Powerhouse Ultimo Revitalisation
SSD 67588459
500 Harris Street Ultimo

Submission from LIONEL GLENDENNING
October 6th 2024

Re: Submissions and Amendment Report
Ethos Urban
Powerhouse Ultimo Revitalisation
SSD 67588459
500 Harris Street Ultimo
September 3 2024

Figure 17 Tree removal and tree retention

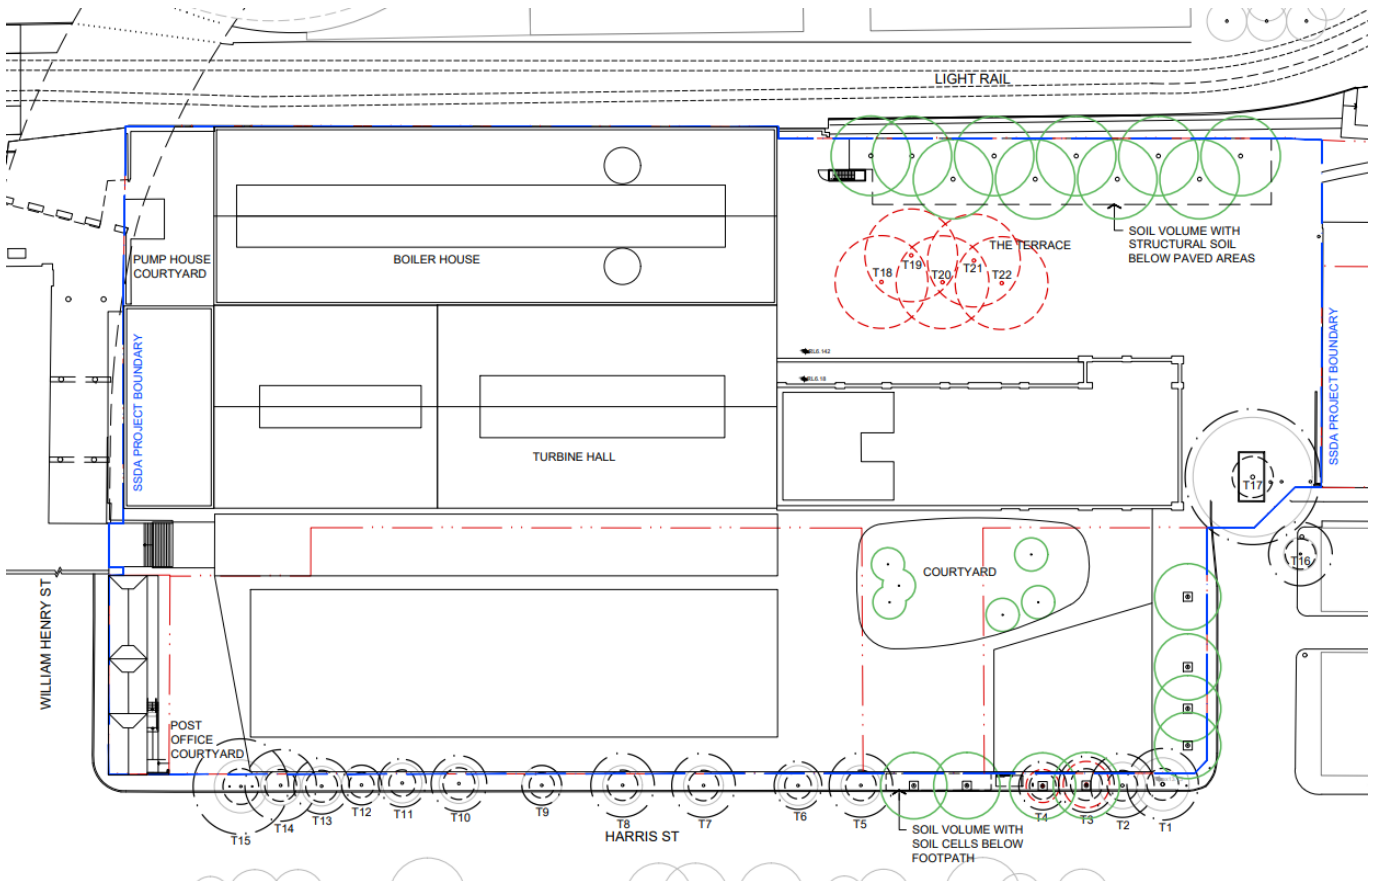
Some mature trees are to be removed on ideological grounds yet Plane trees are popular urban trees, hardy, well established and providing relief as few native species do when planted isolated in a degraded car-infested urban environment.

Figure 19 Proposed entrances to the revitalised Powerhouse

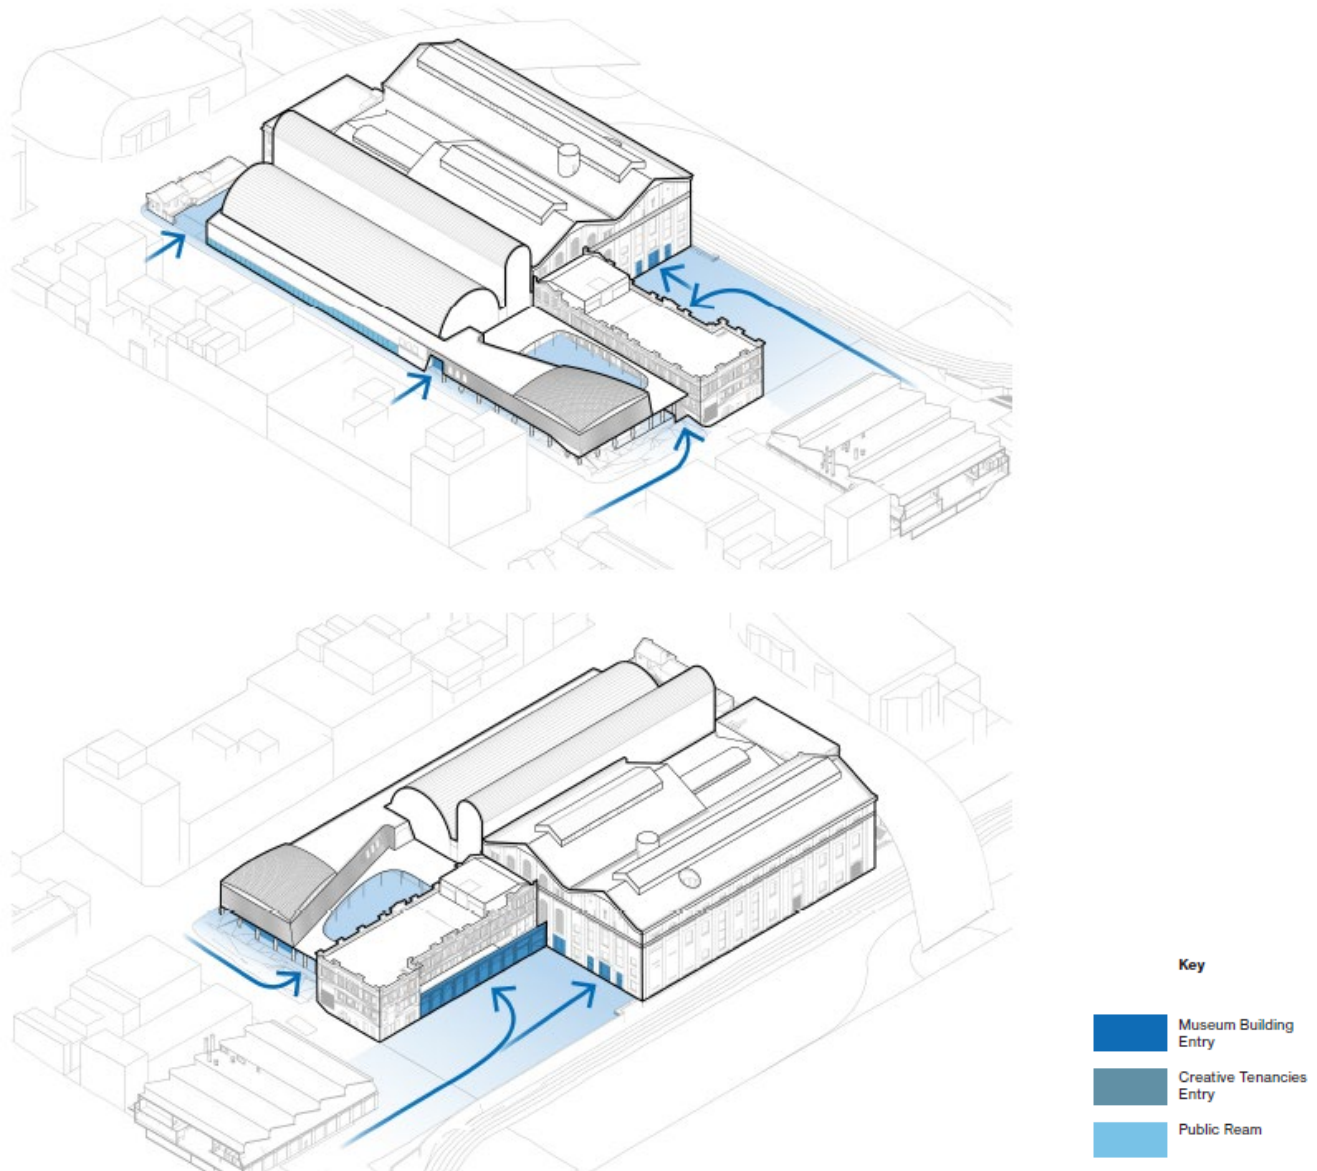
Key elements on Harris St of ambiguous, obscure unresolved forms, odd junctions and gross overall proportions ignore context and the existing streetscape: the solid brick 'row of 'shops' and the mean public entry – more a 'side door' - are unwelcoming and at odds with both Harris Street's recognition as the main street 'spine' of the Pyrmont peninsula, and the fact that Harris Street has been and should still be the major entry to the Powerhouse Museum. This is where buses stop, where school and tour buses stop and where people can arrive and depart the Museum at grade. Car parking is ignored as an issue.

There is already a public entry/exit at the lower courtyard and this has worked perfectly well with the main Wran entry off the existing open sunny public space of the Harris Street forecourt.

The poor decision to rework the Museum's circulation to prioritise arrival at the Grace Bros Courtyard via the Goods Line and Haymarket and the Light Rail ignores the reality of the steep grade between Harris Street and the Goods Line and, the importance of bus transport to the site.

Figure 28 Proposed Gathering Terrace, outlined in red

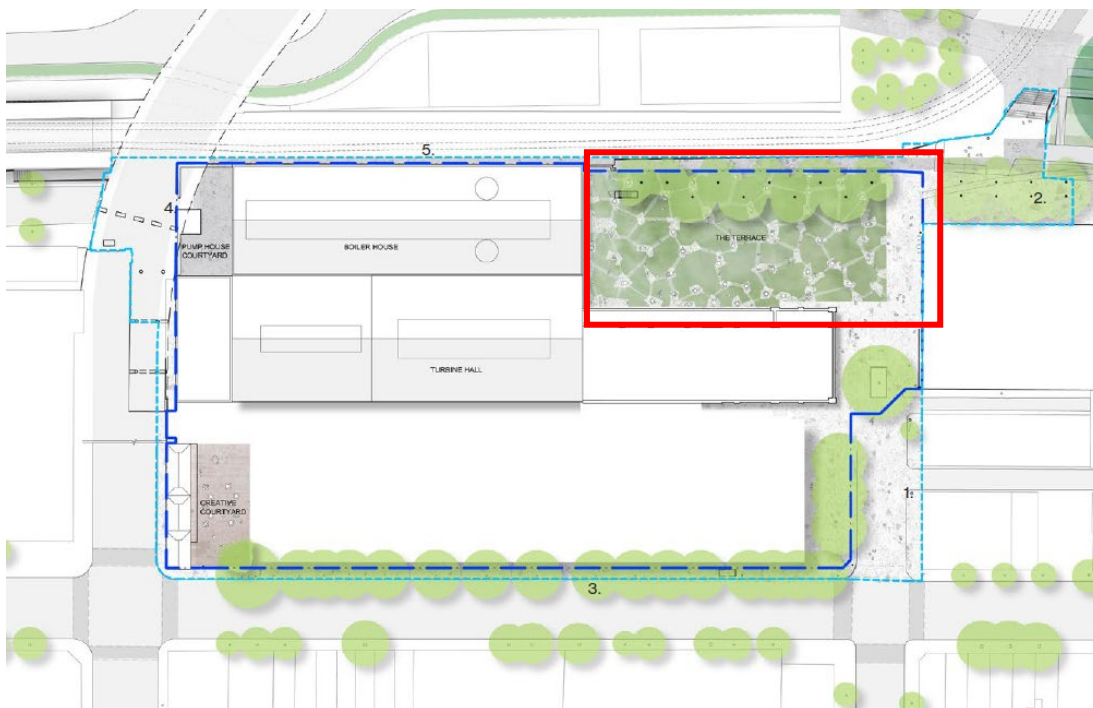
When compared with the existing public entry and spaces, solar access in winter will mean the sole large public space, the SE 'Terrace' Goods Line lower courtyard, will be in deep shadow and windswept.

The SE court or 'Terrace' at the end of the Goods Line - is far from being a welcoming, attractive and accessible public space. After traversing the urban mess of Hay Street and Darling Drive and the precipitous level changes, one will hopefully arrive at the SE Court, presently the end of Macarthur St/Harwood Building NE corner where one will be 70m from the lower Museum entry which has no cover from the elements. Note: the existing entry and exit has a covered way the length of the Switch House which protects movements of people, museum objects and sundry deliveries.

The 'traverse pathways' across the Terrace link plantings are of doubtful urban character. Unlike the vast majority of urban spaces that characterise museums and galleries across the world, this space will be in the shadow of the buildings across the Goods Line and, the great bulk of the Turbine hall and Boiler Hall.

The space will be overwhelmed by 6-10,000 visitors a week queuing without cover, possibly at a Museum entry to the Switch House. Note that city gardens are very high maintenance spaces and the combination of people traffic as well as object movements and deliveries will exacerbate wear and tear despite the rather clumsy proposal for removable paving slabs for truck/vehicle traffic.

The SE Court or Terrace 'garden' concept is naïve and the minimal amendments are a poor attempt to overcome fundamental flaws in design and development of a public space for an imagined 2,000,000 visitors a year and for the existing local Ultimo /Haymarket community.
